## Appeal Decision

**Appeal Ref: APP/R5510/W/25/3366678**

**68 Knoll Crescent, NORTHWOOD, HA6 1HY**

- The appeal is made under section 78 of the Town and Country Planning Act 1990 (as amended) against a refusal to grant planning permission.
- The appeal is made by Mrs Geetanjalee Devani against the decision of the Council of the London Borough of Hillingdon.
- The application Ref is 36488/APP/2025/292.
- The development proposed is the conversion of existing dwellinghouse into 2 no. self contained flats.

PROPOSED GROUND FLOOR

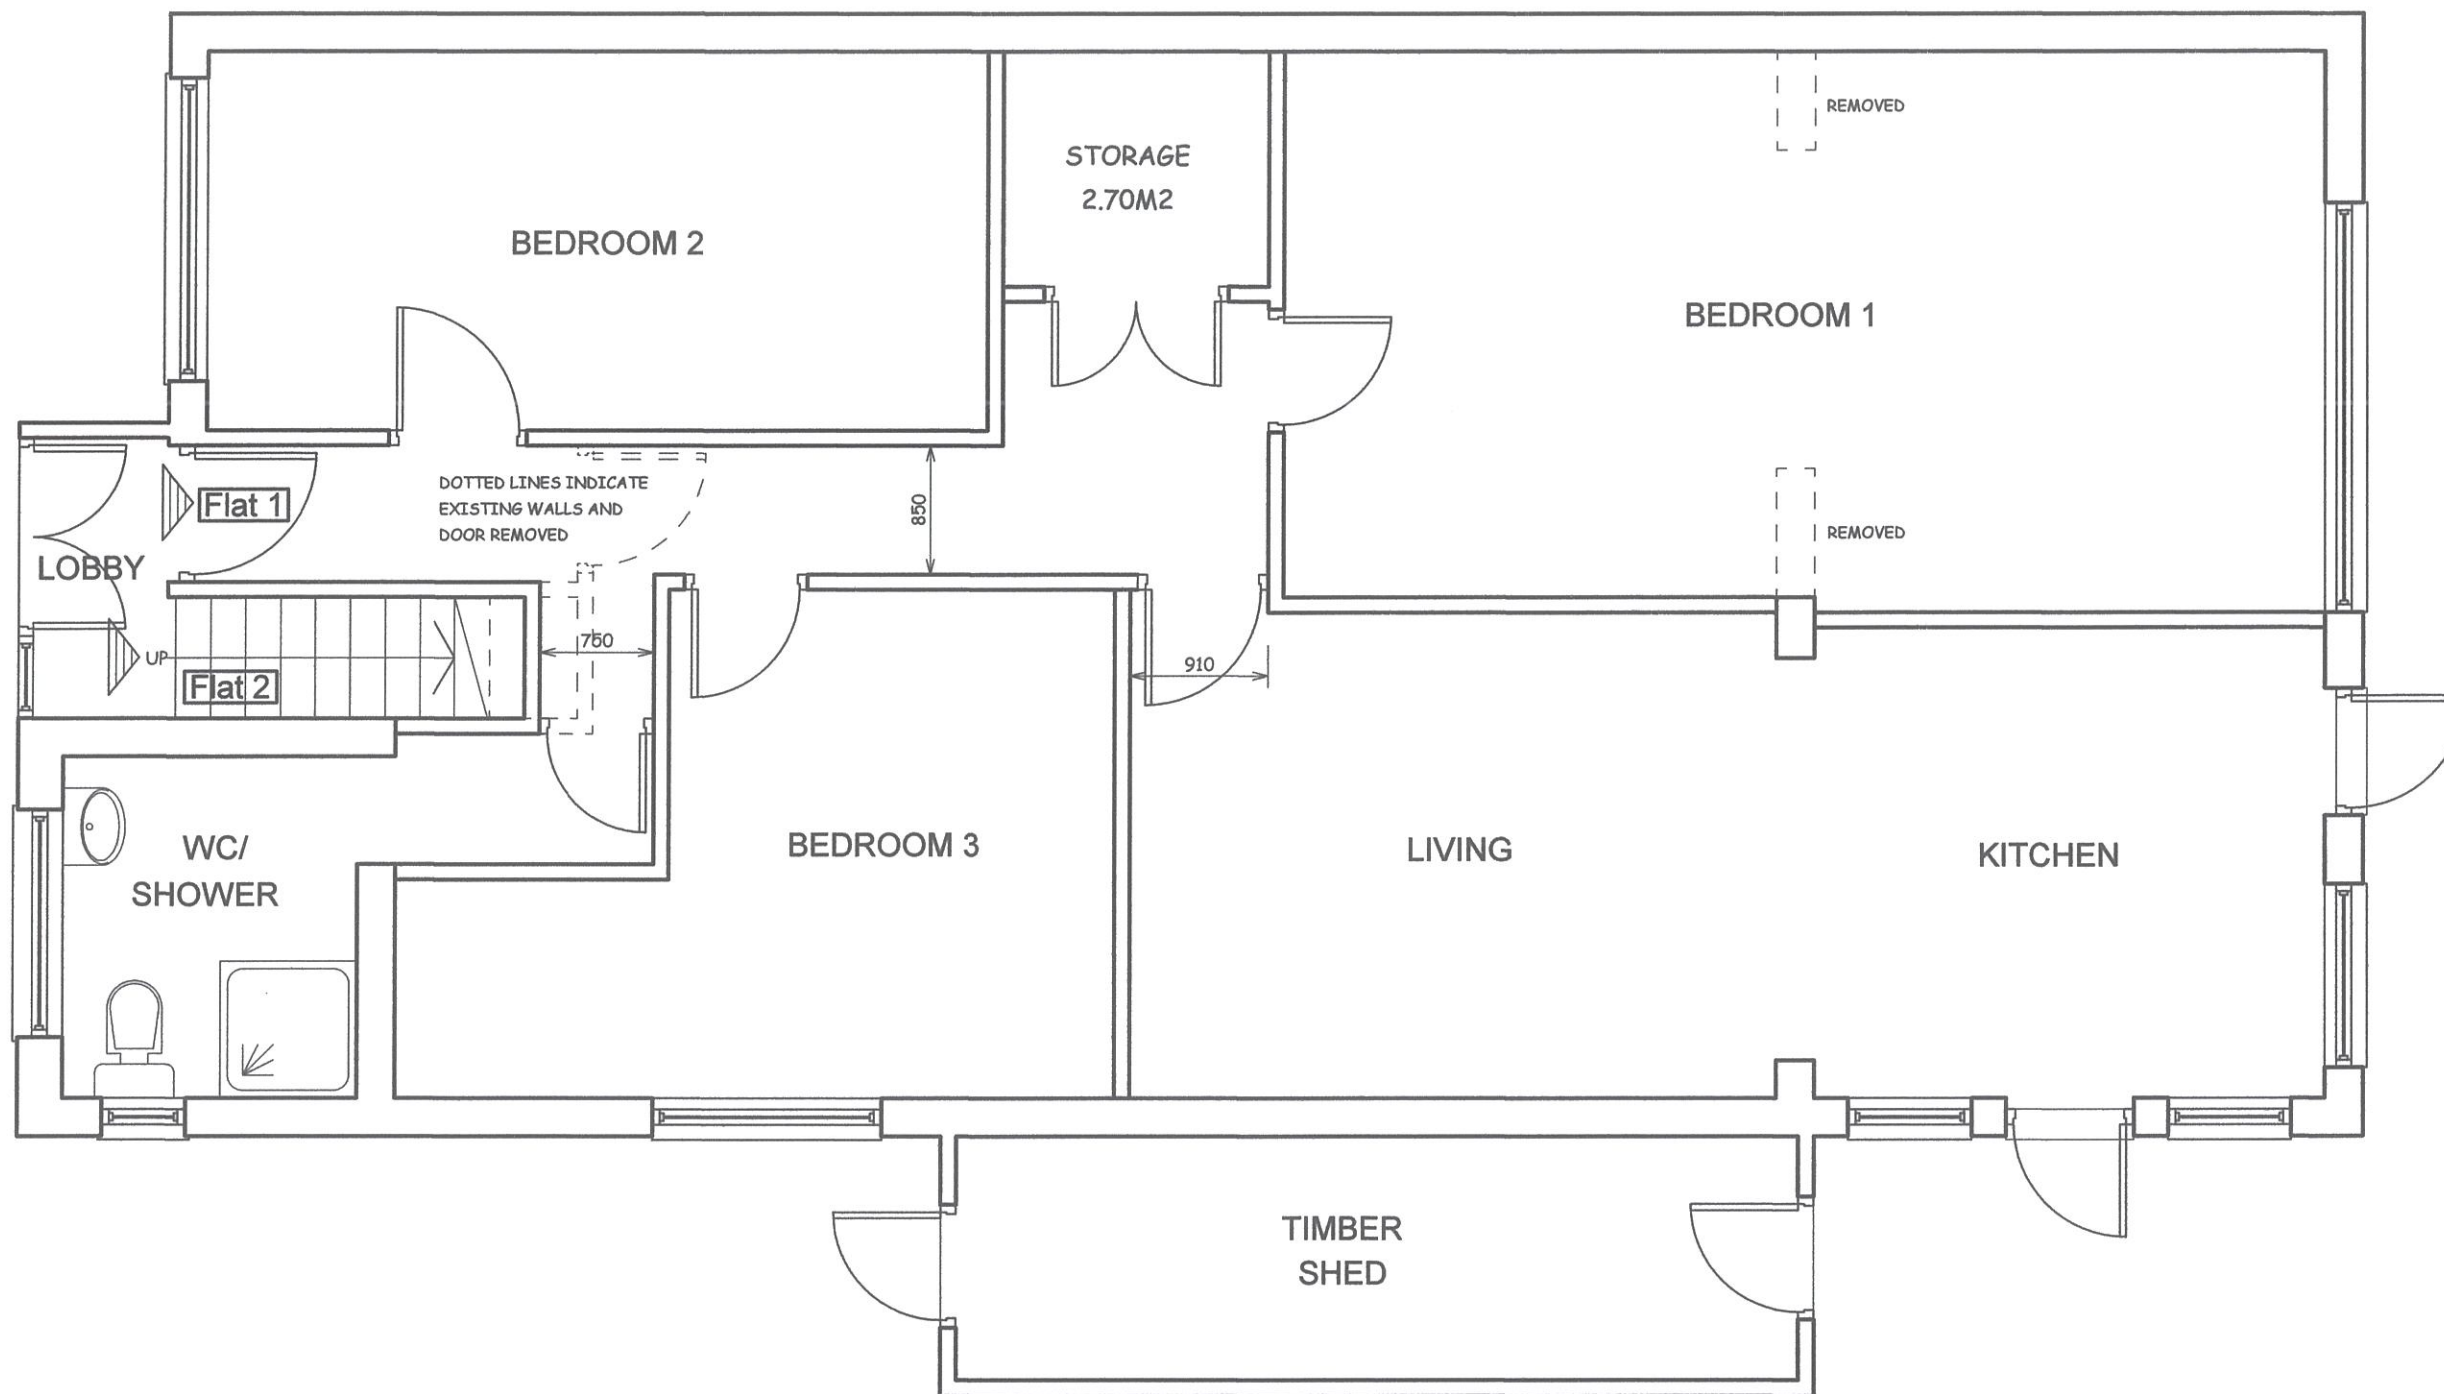
5. The ground floor flat would contain 3 bedrooms. The proposed bedroom 3 would be served by a single window in the side elevation of the building. This window would face onto the narrow space between the flank wall of the house and the high boundary fence. I consider that this would offer a very restricted outlook for this room and would mean that its access to light would be restricted. In my judgement, this would not provide a suitable residential environment for any future occupiers of this flat.

6. The Council also raise concerns that bedroom 2 on the ground floor would have its window very close to the main entrance to the building and close to the adjacent car parking space. In relation to the parking space, I consider that it would be practical to allocate that space to the ground floor flat, if the scheme were to go ahead, and so little unacceptable disturbance would arise. In relation to noise from the entrance, this would only be for the 2 individual properties and in terms of 'external noise' would only be that generated by the upper flat. I would envisage that this would be limited in its effects and not unreasonable.

7. It is not clear if both flats would have access to the rear garden area and on what basis or division. The Council indicates that if the whole area were to be communal, it could give rise to privacy issues for the ground floor flat. Conversely, if the whole area were for the ground floor flat only, then the upper floor would be unacceptably affected. I agree that the lack of certainty means that the proposal could fail to provide a suitable residential environment in this respect and this adds to my objection to the proposal.

BLOCK PLAN

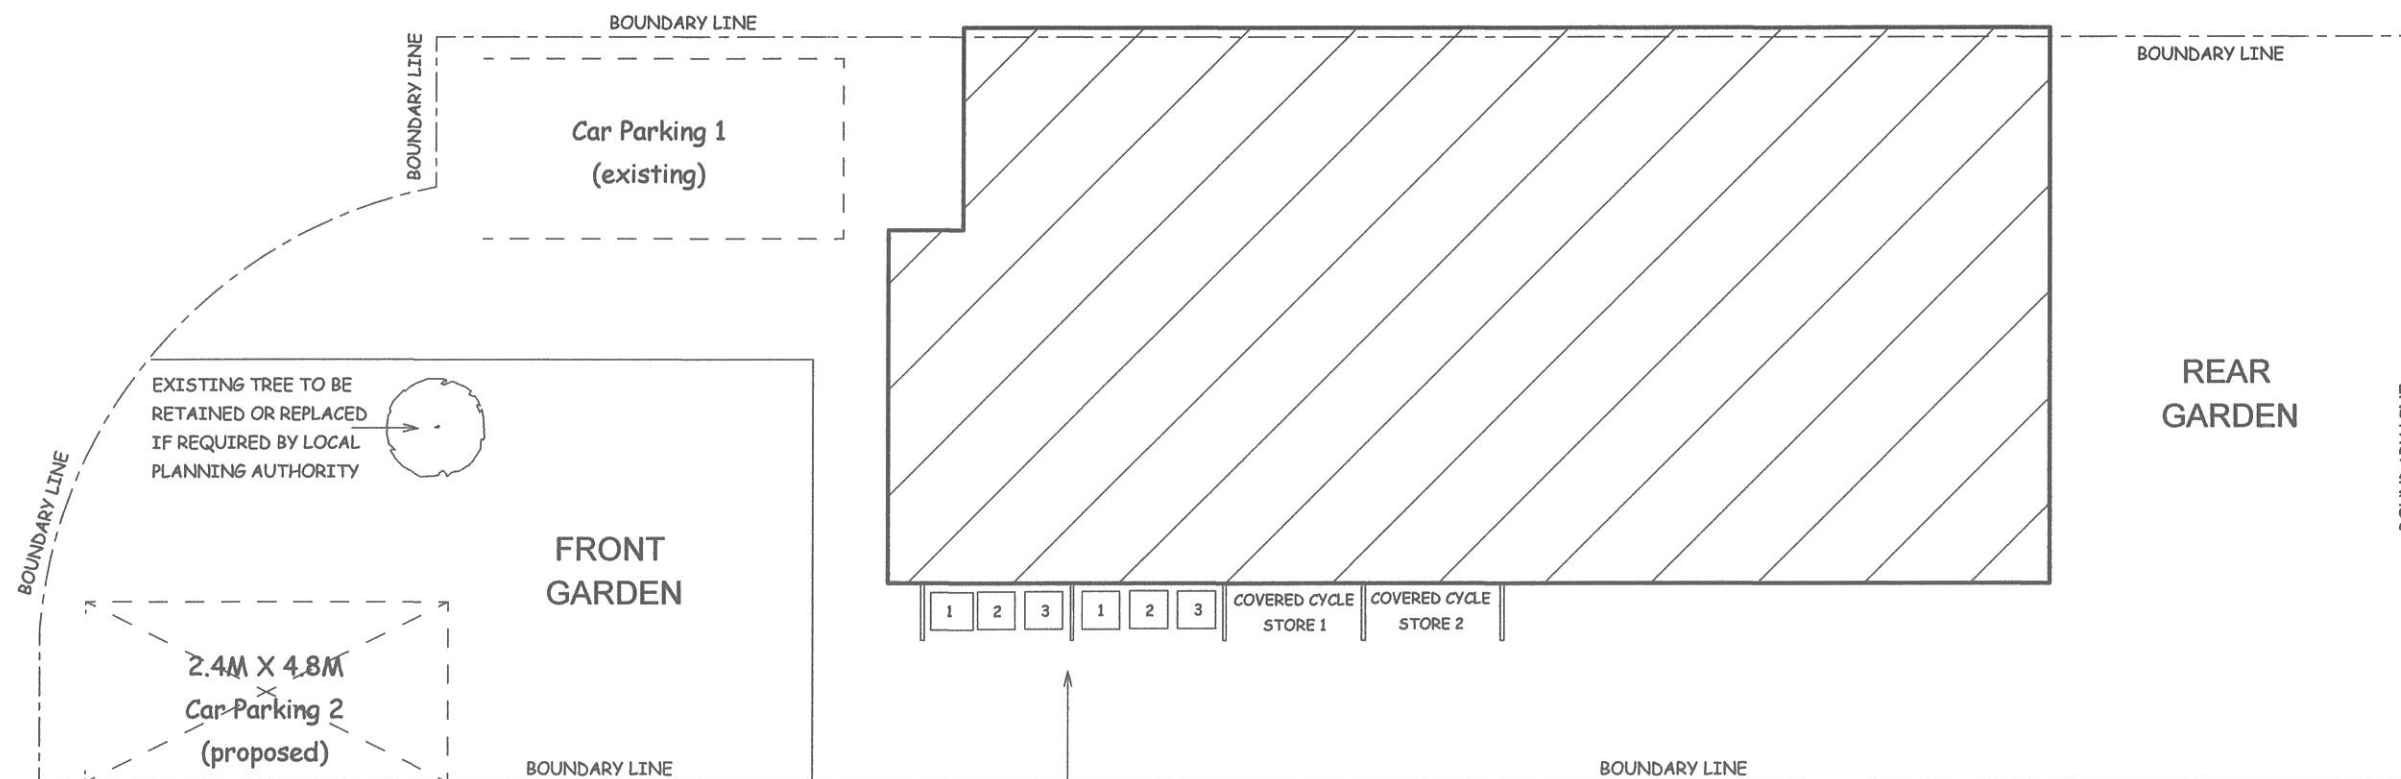
9. The frontage of the site contains a tree that is included with a Tree Preservation Order (TPO). The proposed additional car parking space would be sited close to this tree. The tree currently sits within an area which is raised from the adjacent road and pavement and it seems inevitable that the proposed car parking space would need to be excavated to some degree. The appellant's submissions do not include any assessment of what works would be required to provide the parking space nor any assessment of the likely effects of those works on the well-being of the protected tree. Taking account of the proximity of the parking space to the tree, there is a legitimate concern that the well-being of the tree could be affected. In the absence of a suitable assessment, the future health of the tree cannot be ensured. Therefore, the proposal is contrary to Policy BE1 of the Hillingdon Local Plan Part 1 Strategic Policies and DMHB 14 of the DMP.
